## Benjamin Wallace - Re: Pine Tree

**From:** Benjamin Wallace  
**To:** Rich Brobst  
**Date:** 11/30/2011 11:05 AM  
**Subject:** Re: Pine Tree  
**Attachments:** 1064 Brighton Ave Plaza - FIREFIGHTER BUILDING MARKING SIGN.pdf; Benjamin Wallace.vcf

Second I've finally had the opportunity to do a complete review of the permit submittal as I've only now received the permit from City Hall. I think this is the one you were going to get me a cleaned up operations matrix deleting the apartment reference and adding the master box column. Also I don't recall having received a master box application yet and can't find one anywhere. Please e-mail me a completed master box application. The building name is going to be Pine Tree Shopping Center and the address we're going to use will be 1100 Brighton Ave. Additionally I've identified several issues with some of the strobe spacing/ rating and a lack of a smoke detector over a NAC power supply and need a revised/ as-built set of plans indicating the corrections.

Little Caesar's

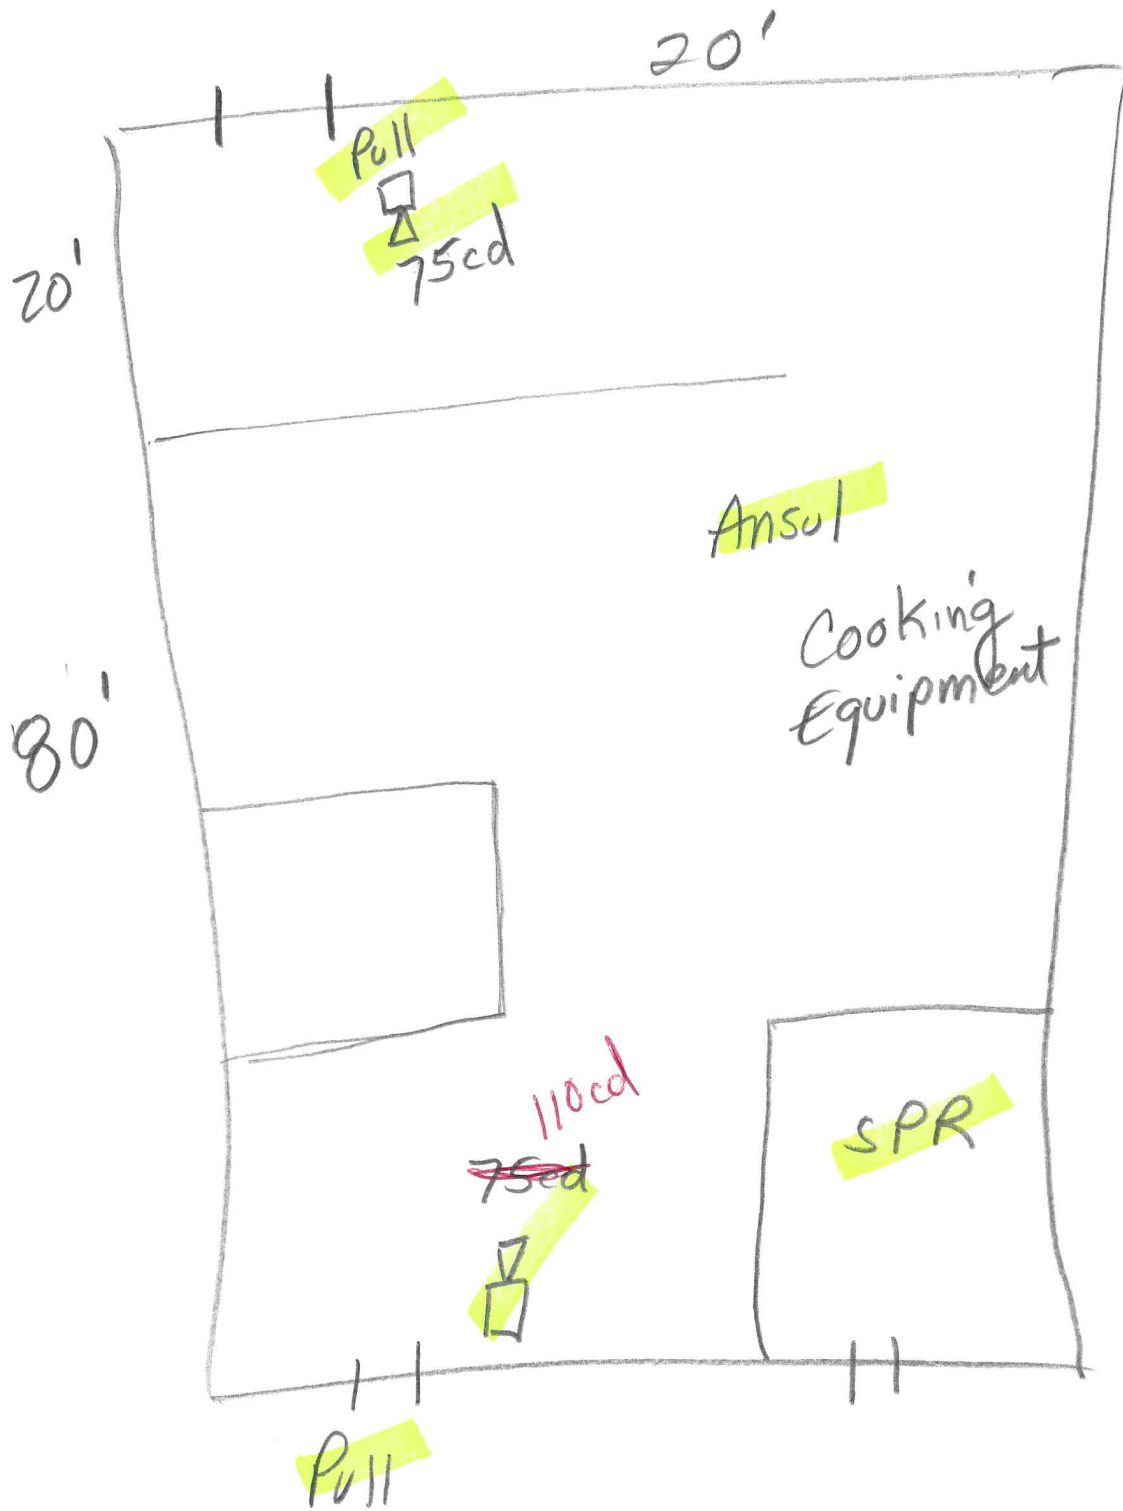
Strobe spacing:

- Full Belly Deli rear
- Fashion Bug back room
- Dollar Tree bathroom hall
- CVS back room
- Big lots most rear room/ corridor
- Little Caesar's front strobe isn't adequate to cover the middle of the space
- Hair Excitement front
